STORMWATER AUDIT (STAGE 1)

JBA Project Code 2022s0125
Contract Stage 1 SWA – Brennanstown Road
Client Cairn Homes PLC
Prepared by Michael O'Donoghue
Subject Stormwater Audit Stage 1 Report

JBA Consulting have been contracted by Cairn Homes PLC to undertake a Stage 1 SW Audit of the surface water drainage design prepared by Waterman Moylan Consulting Engineers for the proposed SHD at the Brennanstown Road, Dublin. The audit has been completed in accordance with Dún Laoghaire Rathdown County Council's (DLRCC) Stormwater Audit Procedure (Rev 0, Jan 2012) as set out below.

Figure 14. Proposed Drainage Layout

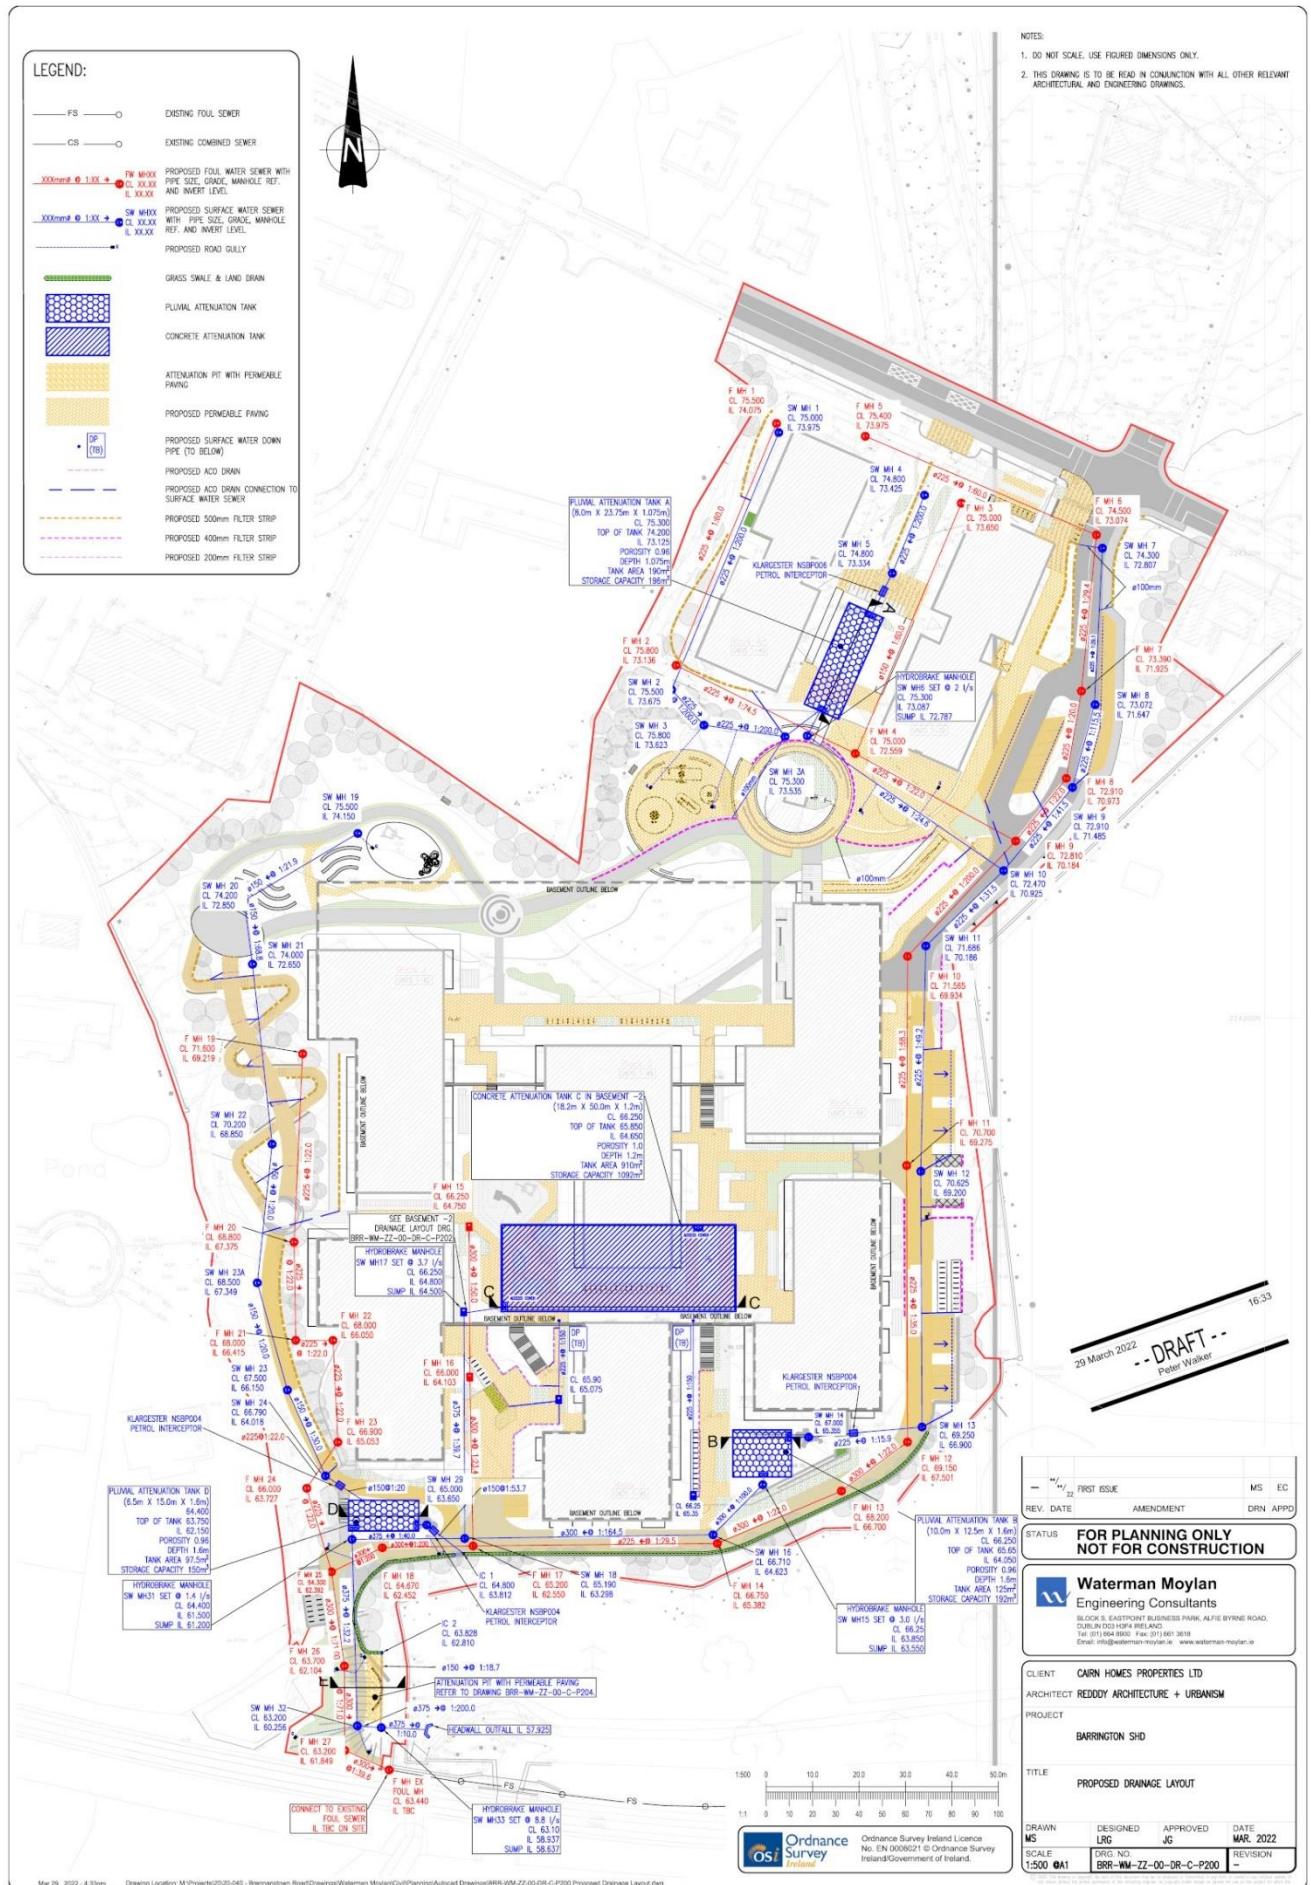
FF 2a. The extent of permeable paving differs from the drainage layout and the SuDS layout.

FF 2b. One of the filter drains is shown to be discharging into the foul network.

FF 2d. The filter drains are adjacent to roadways with falls exceeding 1:100, a gradient where interception will no longer be provided. This should be addressed if WM are to consider these as interception measures.

2	BRR-WM-ZZ-00-DR-C-P200 Proposed Drainage Layout			
a	The extent of permeable paving differs from this drawing and P203.	Clarify extent of permeable paving.	Please refer to updated drawings showing same extent of permeable paving.	Acceptable
b	There appears to be a filter drain connection at F MH 20.	Amend drawing to remove cross-connection.	Noted and amended.	Acceptable
c	A petrol interceptor is located upstream of Tank A. The upstream catchment does not appear to have any run-off from carriageway or parking surfaces. Therefore it may be possible to remove the interceptor.	Clarify purpose of interceptor upstream of Tank A.	The are upstream of the petrol interceptor is currently use for fire tender purposes. Should the fire tender strategy changed at detailed design stage, petrol interceptor in Catchment A may be removed as not vehicles are allowed to drive in this area.	Acceptable
d	Given the steepness of the proposed drainage, it is likely that the filter drains will be installed at similar gradients. Should they be installed at steeper gradients than 1:100 they can not be deemed to be providing interception.	Provide gradients for filter drains and swales.	Please refer to drawing P204 which shows a longitudinal sections to be used for filter strips and swales when the footpath/road levels have steeper gradients than 1:100. Therefore, all proposed swales and filter strips on site will provide interception.	Acceptable
